70 Anderson Street - Final Traffic Comments

Hi Shukria – I have reviewed the revised/supplemental application materials and offer the following final traffic comments, as an update to my final comments.

PERPENDICULAR SIDEWALK RAMP
1" = 5'

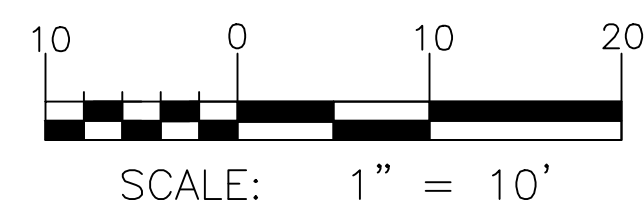
I continue to review and coordinate the design of the proposed sidewalk ramp on the project corner. I am coordinating with other City staff on the ramp design. Additionally, the crosswalk on East Lancaster Street shall include a fully compliant ramp on the south corner of the intersection.

Status: Adjustment to the ramp design is suggested given that a crossing of Anderson Street is not formalized. The applicant shall provide a revised layout for review and approval. The applicant is only responsible for improvements on their corner of the intersection.

DRAWING NO. **C-10**

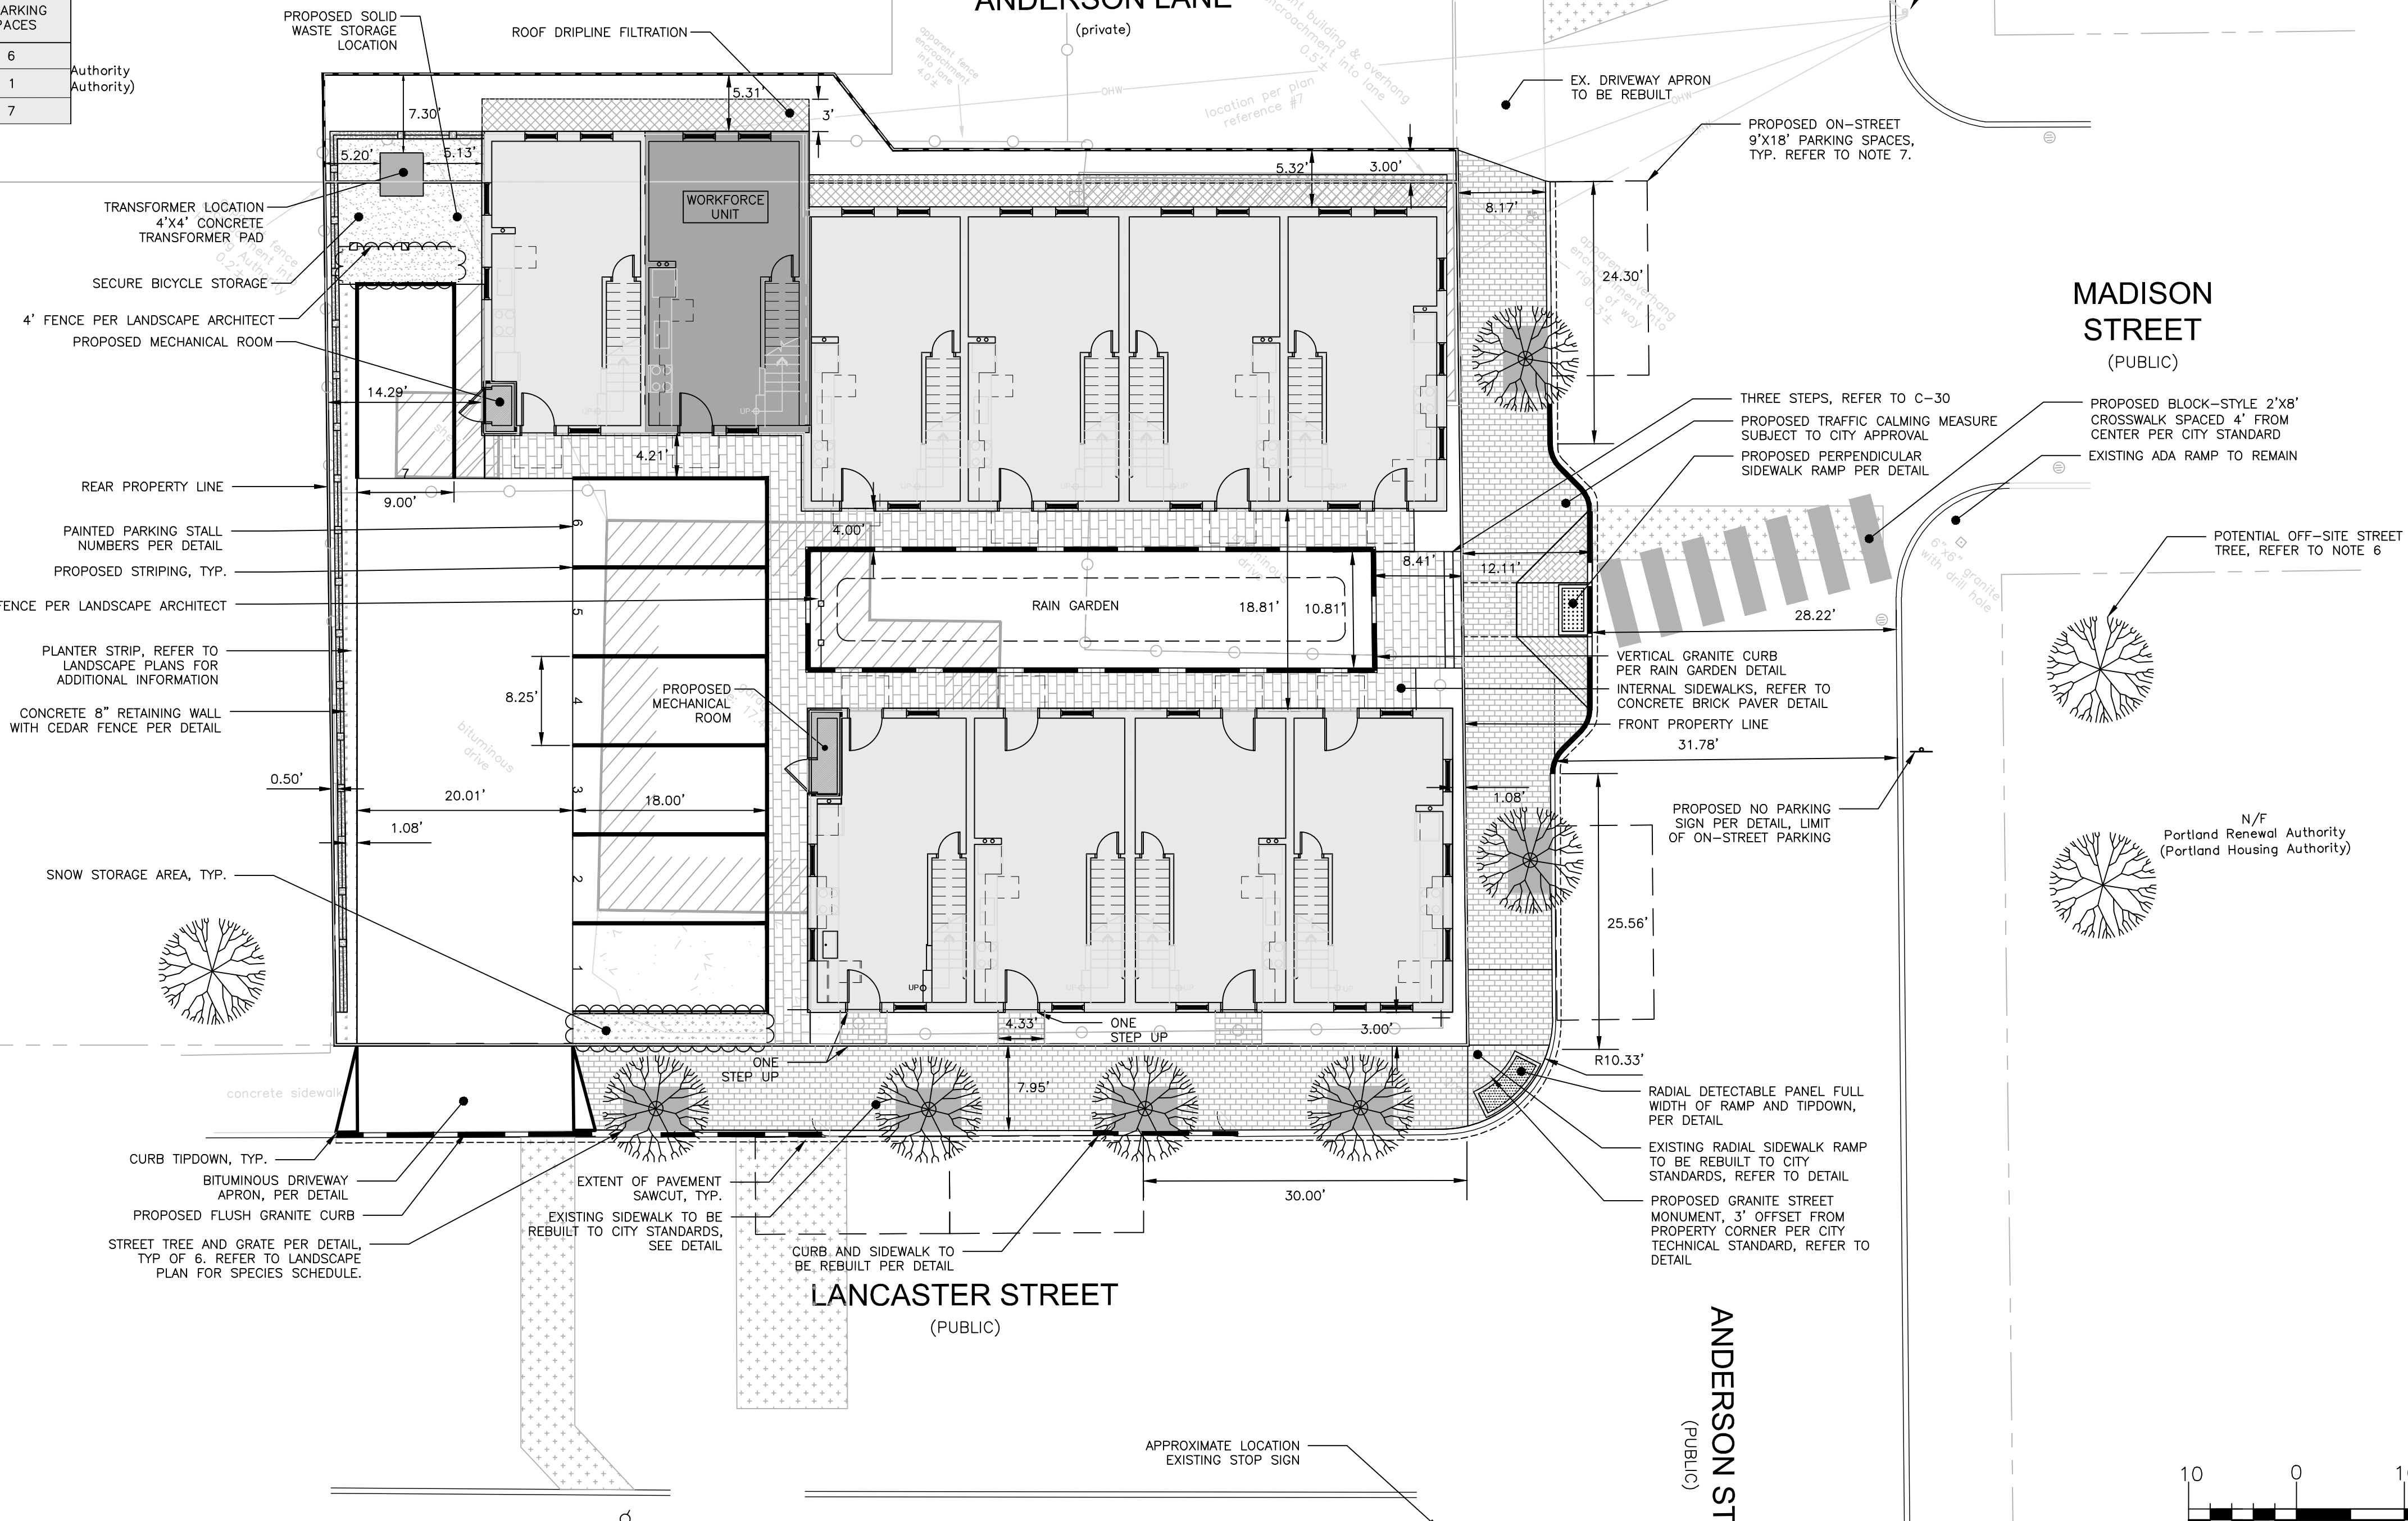
· The applicant is proposing parking spaces (one space meets City standards) that are slightly narrower than City standards (8.25 feet vs. 9 feet). An Auto-turn analysis should be provided documenting adequate vehicle circulation.

· The parking layout will likely require vehicles to back out into East Lancaster Street. Given low traffic volumes on East Lancaster Street and low trip generation from the site, I find this condition to be acceptable.

· The applicant is proposing a parking aisle width of 20 feet and this does not meet the City standards. An Auto-turn analysis should be provided documenting adequate vehicle circulation.

· The driveway apron along the sidewalk shall have a maximum cross slope of 2%. The plans shall include details specifying this requirement.

Status: The applicant has provided an Auto-turn analysis and I support a waiver from City standards given site characteristics.

Status: I have no further comment.

Status: The applicant has provided an Auto-turn analysis and I support a waiver from City standards given site characteristics.

Status: The plans have been revised to note this requirement and I have no further comment.
